**Able Marine Energy Park
Development Consent Order 2014
Material Change no. 2**

Planning Inspectorate Reference: TR030006

**Written Representations by
the Environment Agency
Unique Reference Number: ABMC2-R19029**

14 December 2021

Figure 8-14: Google earth Imagery of Hawkins Point (2007 and 2019)

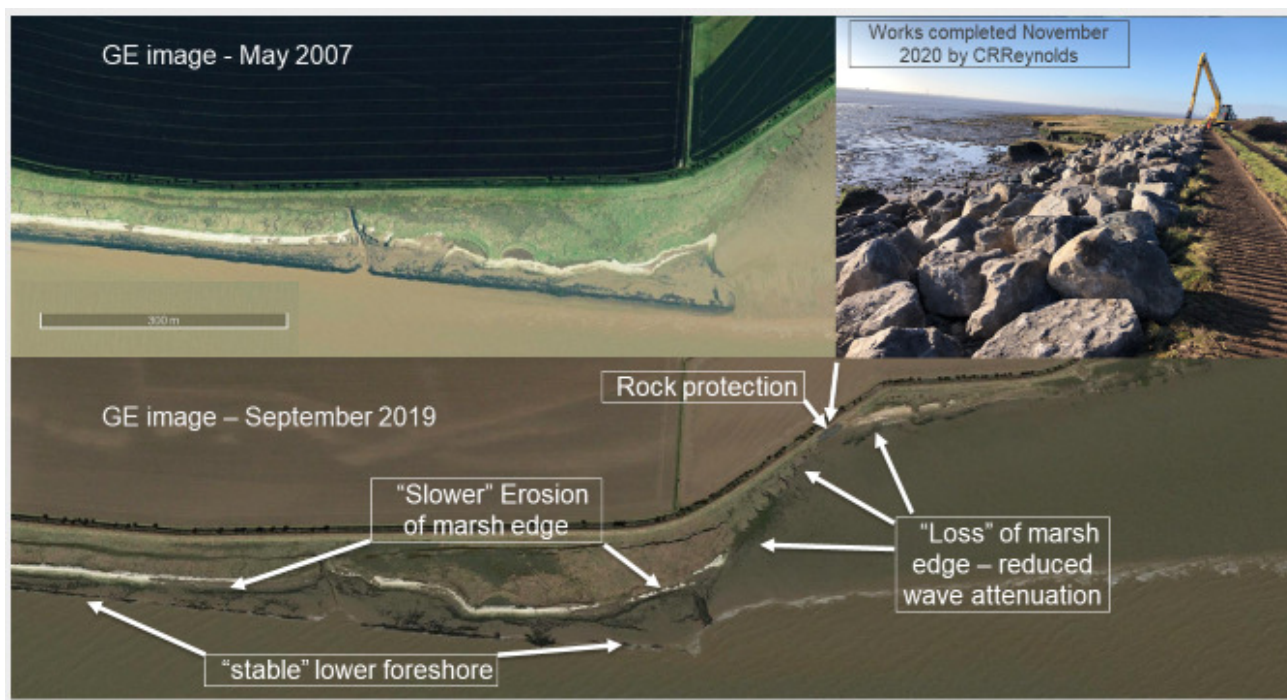
- 3.5 The EA requested that potential impacts from increased wave activity resulting in foreshore erosion to the west of Hawkins Point needed further consideration in respect of the risk to habitat/flood defences. The Applicant has provided an explanation of the impacts on the foreshore at Hawkins Point (included in Appendix 1 to the SoCG). The EA is now satisfied with the Applicant's assessment of this.

Figure 8-23: Modelled changes to peak mean spring tide ebb flows (AMEP Amended Quay layout minus updated baseline).

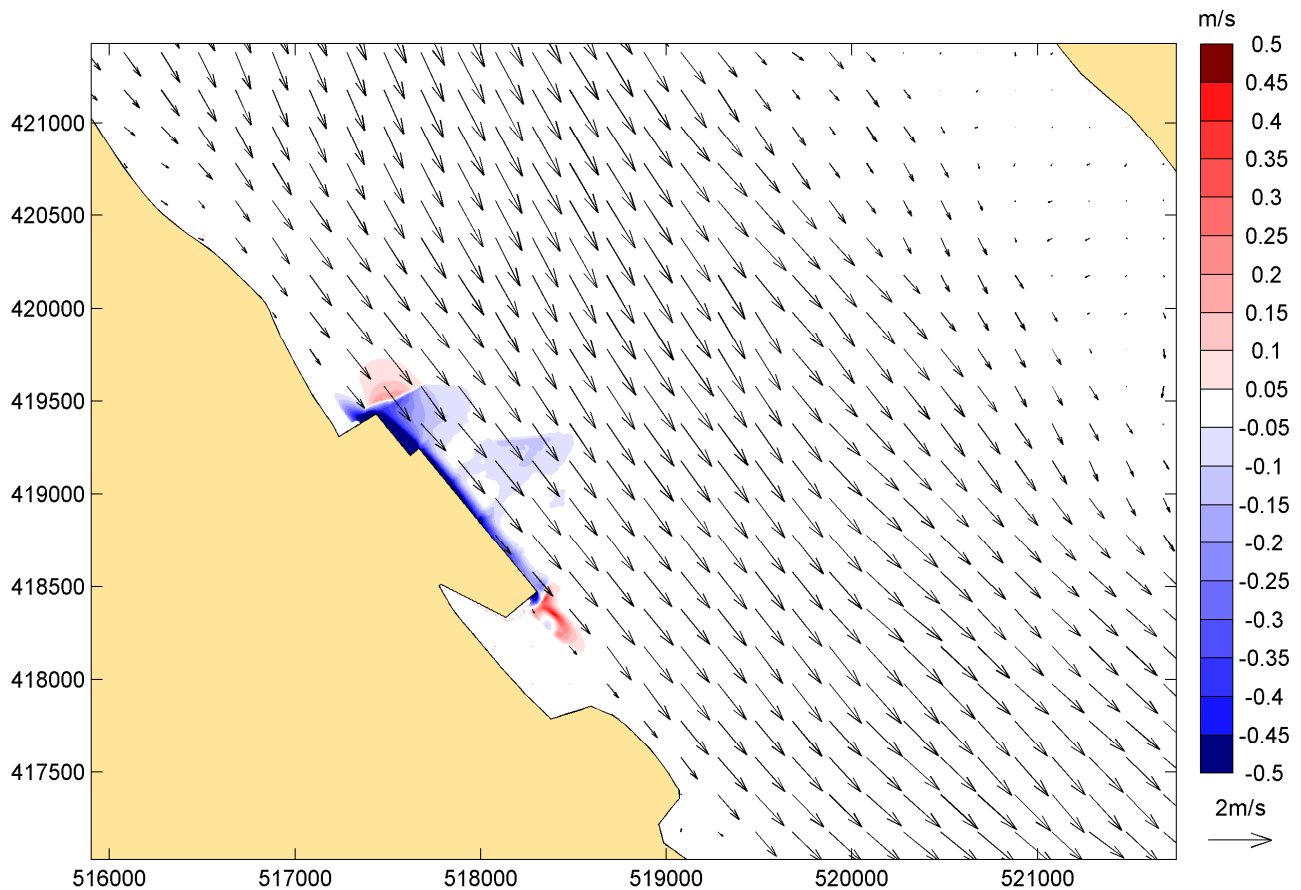
- 3.7 The flow acceleration for the amended quay on the ebb tide is predicted to occur slightly further inshore and over a smaller area than was the case for the consented quay. The increased ebb tide currents are in line with the Project quay and extend downstream for up to 500m on spring tides. Peak speeds on the ebb tide at South Killingholme Oil Jetty may increase by up to 0.3m/s and at the Immingham Gas Jetty by up to 0.1m/s. The EA does not expect that mitigation will be required for this effect.
